From: Dat Tran
Sent: Tuesday, 20 December 2016 3:33 PM
To: 'Amy.Robertson@planning.nsw.gov.au'
Cc: Julie Currey
Subject: RE: 1 Burroway Road, Wentworth Point SSD6387 MOD4

However, we do have some comments which may or may not be outside the scope of MOD 4, but does relate to both ends of the subject through-site link (FERRY WALK) and the interface with Burroway Rd.

DRAWING TITLE
**SEPP 65 DIAGRAM
TYPICAL MID RESIDENTIAL LEVELS
SETBACKS (LEVEL 6 - 7)**

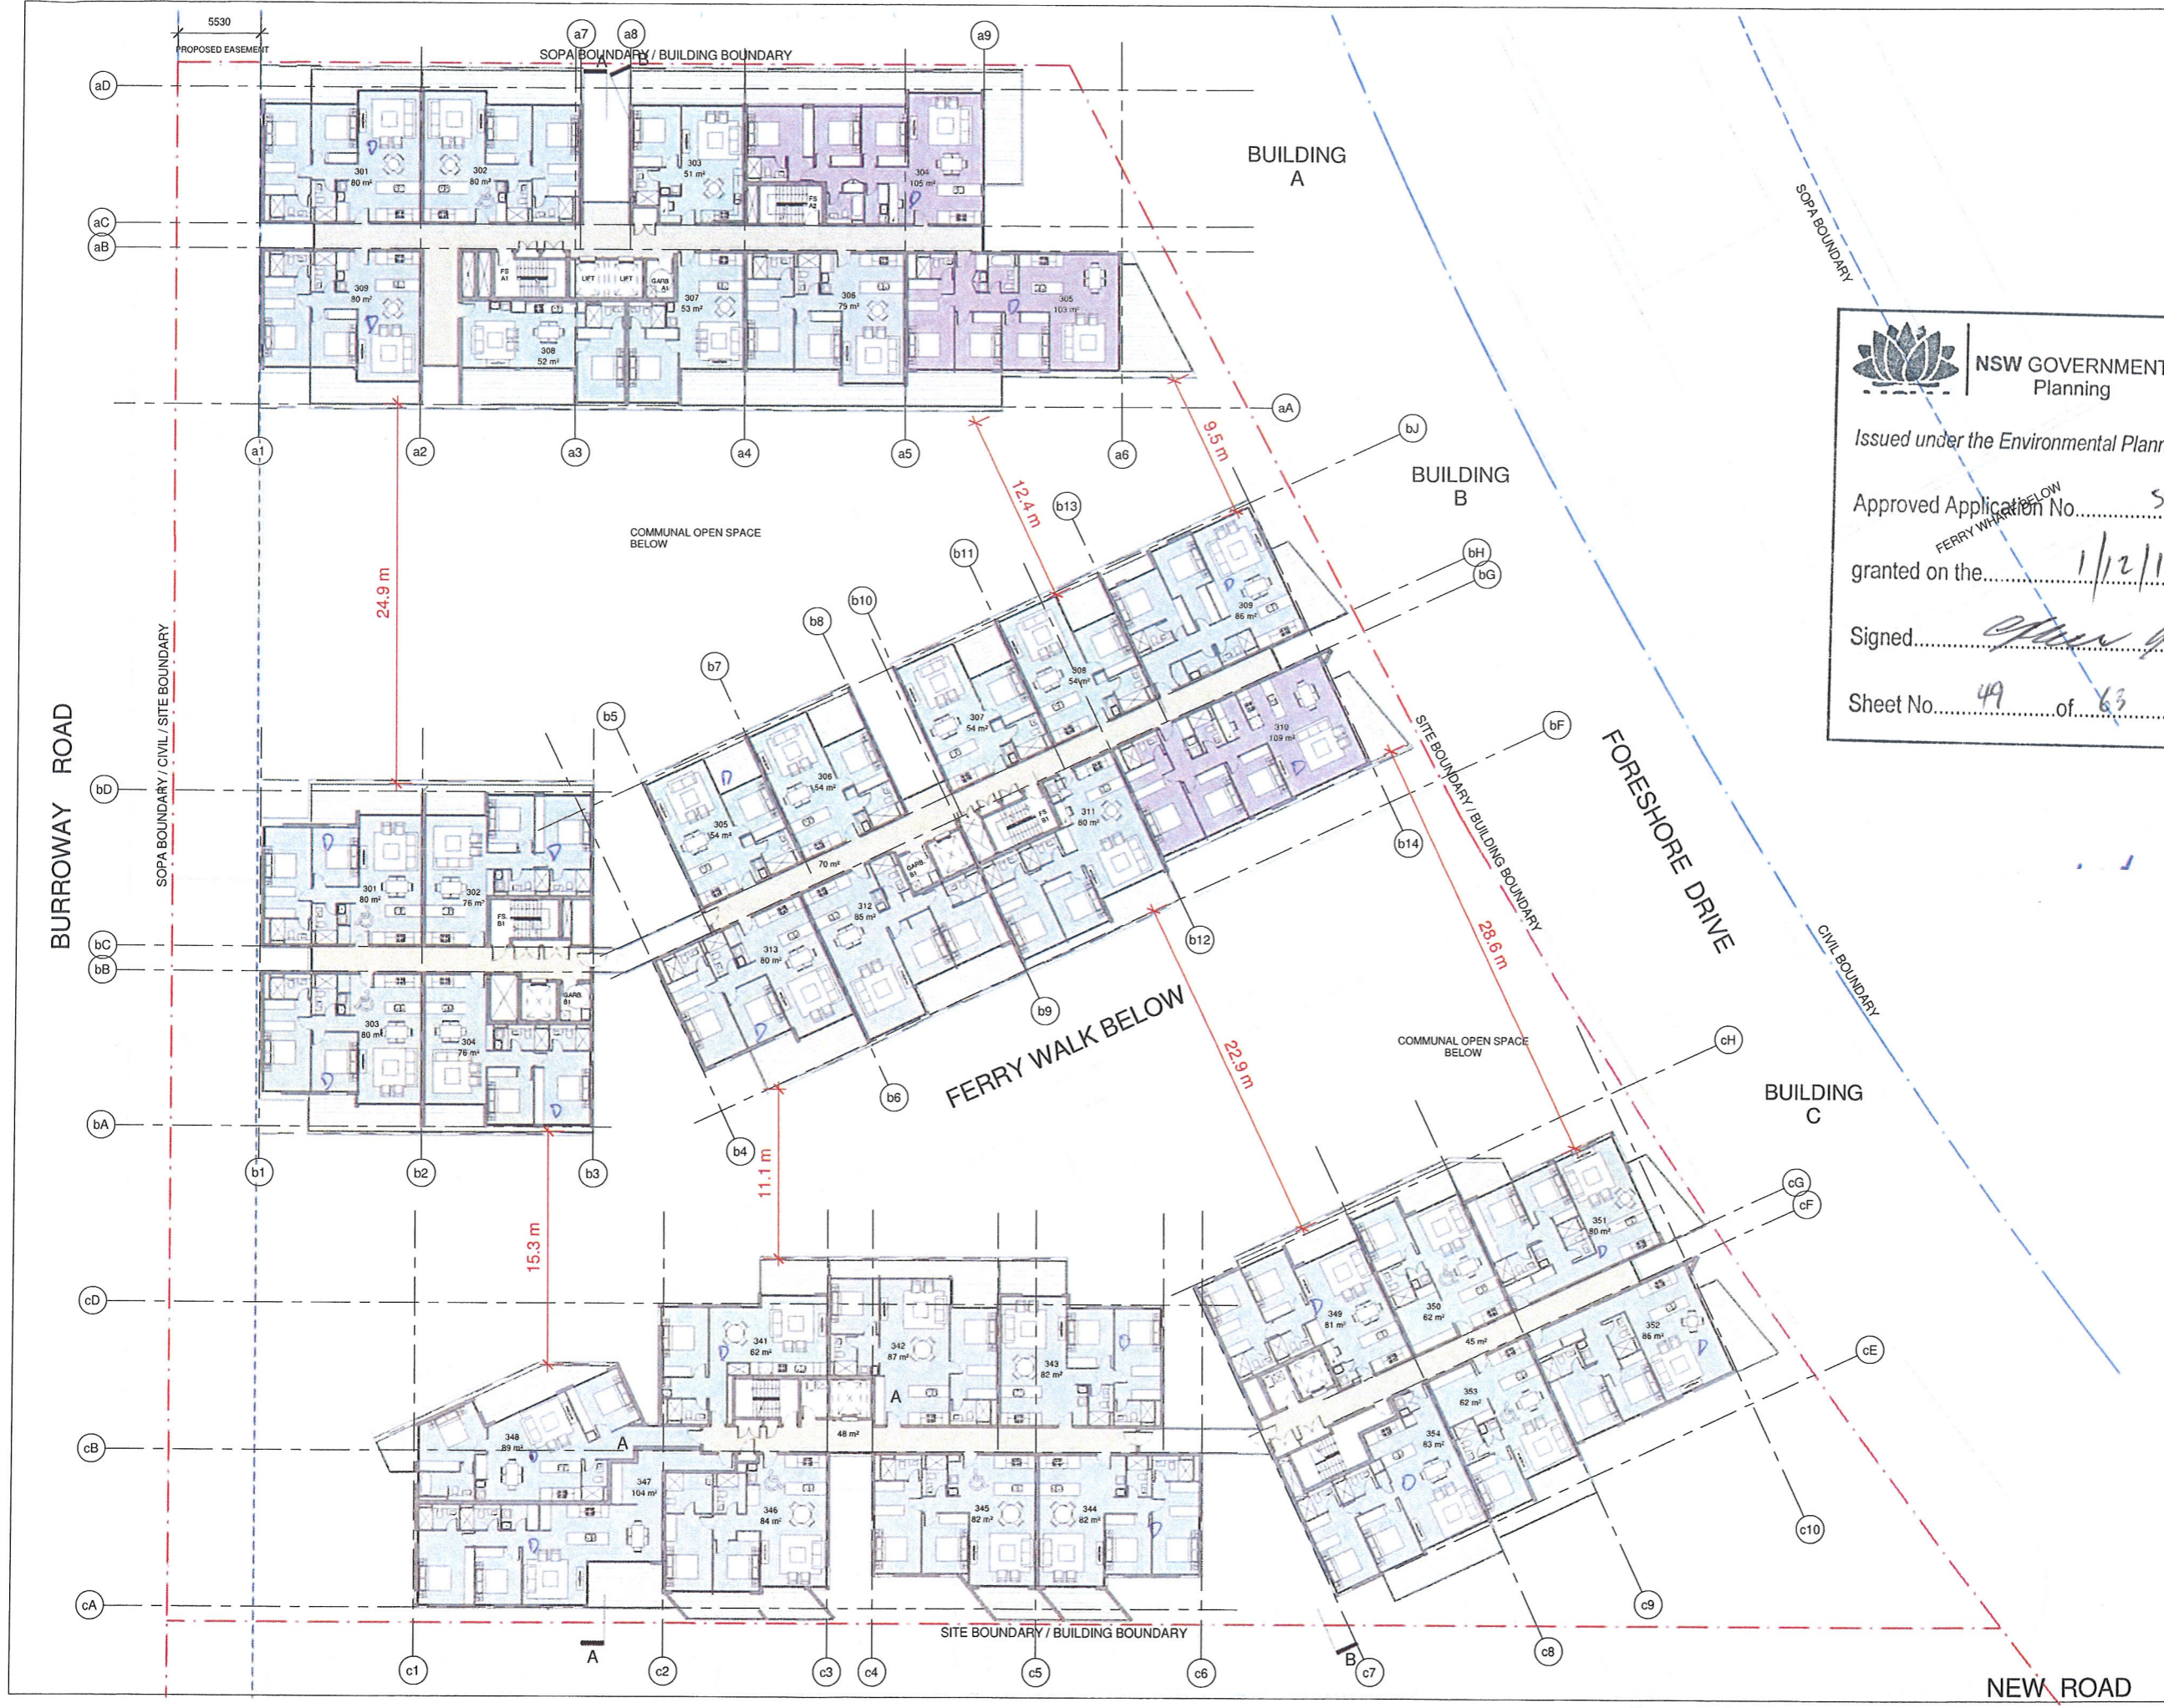
It is the shared responsibility of the developer, SOPA and City of Parramatta Council (CoP) to facilitate safe pedestrian movements connecting to each end of the through-site link – i.e. Ferry Wharf waterfront and Burroway Rd.

The planning and design coordination of linkages and connectivity of safe pedestrian movement through the site remains unresolved. Two Pedestrian crossings are needed at either ends of the through-site link to facilitate safe mid-block movements for residents, shoppers and/or commuters through the Ferry Wharf site.

1. across Burroway Rd to Wentworth Point residential precincts (within CoP LGA)
2. upgraded street adjacent to the Ferry Wharf

The provision of precinct wide pram ramping, appropriate traffic controls and street lighting also needs to be coordinated with CoP. It remains unclear who will ensure this pedestrian corridor is safe and connected.

Recommendation: Require the proponent to prepare a Precinct Pedestrian Access Strategy with inputs from CoP and SOPA.
